From: George Smith
Sent: 01 July 2021 15:09
To: DC Support
Subject: FW: Wroxton MX: 21/00517/F Ecology officer's clear objections and recommendations - 28 June 2021

Subject: 21/00517/F Wroxton MX track

I have looked at the ecological enhancement measures proposals, updated GCN survey and additional information sent to me and will therefore comment further.

Figure 1: Map of Habitat Enhancement Proposals

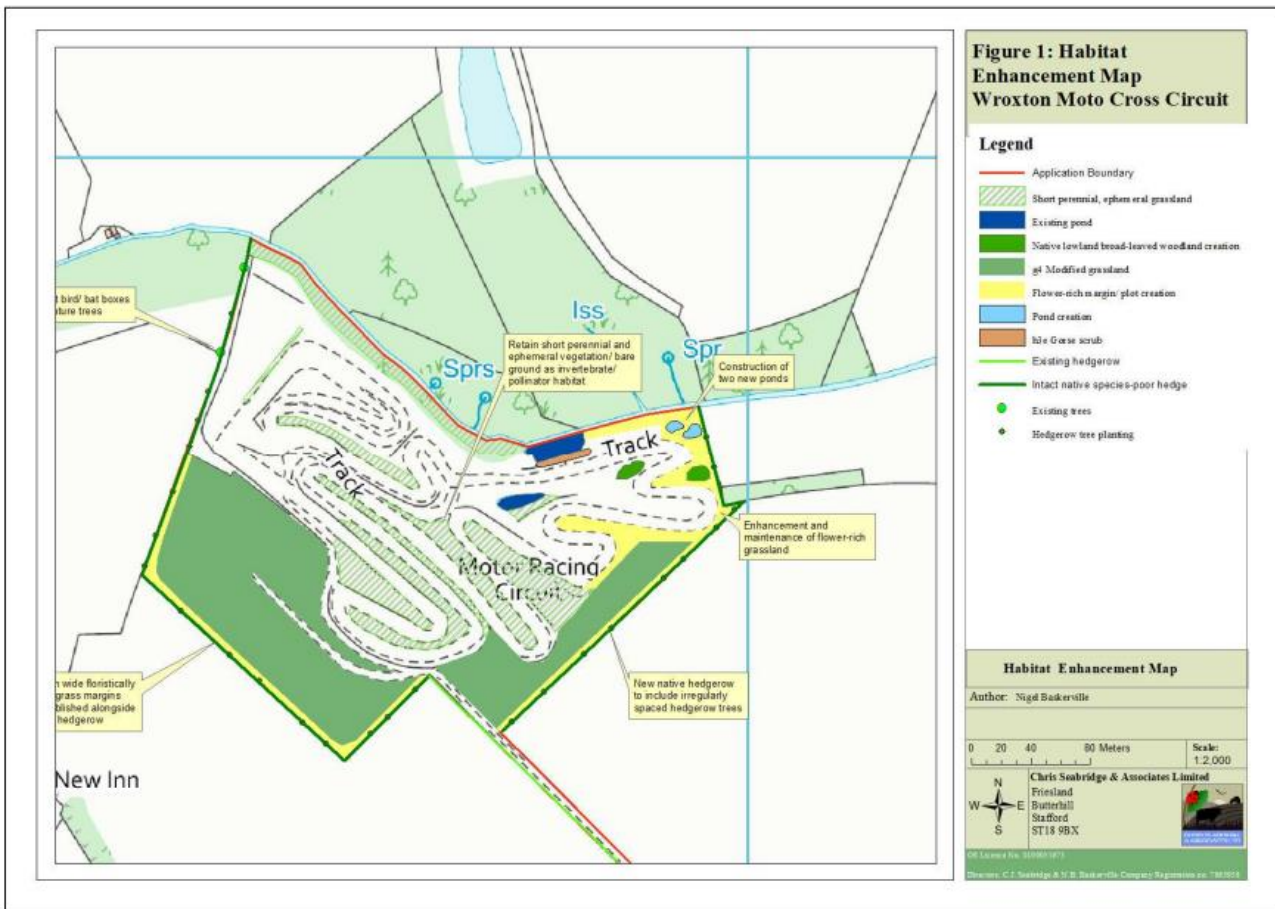
The additional hedgerow proposed to be planted is acceptable in terms of species. There is nothing on ongoing management in terms of frequency of cutting and height. In order to ensure there is a chance of the hedgerow being a successful habitat and in particular the proposed floristically rich margins there will need to be installation of some sort of (wildlife permeable) fence or knee rail to ensure there is no walking or driving/parking close to the hedge or within the margin proposed. 3-4m (and it doesn't say which – it should because an extra metre along this length of hedgerow would dramatically change the net gain achieved) is too narrow to ensure the hedgerow is fit for use by wildlife. With vehicles parked as close as this or potentially earthworks and large machinery this close the hedgerow roots would be impacted. A buffer of 10m to the hedgerow should be maintained where possible. The tree officer could advise further on this also.

The landscape scheme mentions light grazing by sheep will occur. Is this also in the margins? How does this fit in with their management? Or will these be fenced off?

At least one of the areas proposed for small scale woodland creation appears to be on a very steep slope surrounded by track and skid marks. I am not convinced that this would be very successful for trees to survive or reach their natural size in terms of root protection zones? Again I would advise checking with the tree officer or landscape officer as to the likely success of this choice of site but I doubt anything beyond poor condition could be achieved.
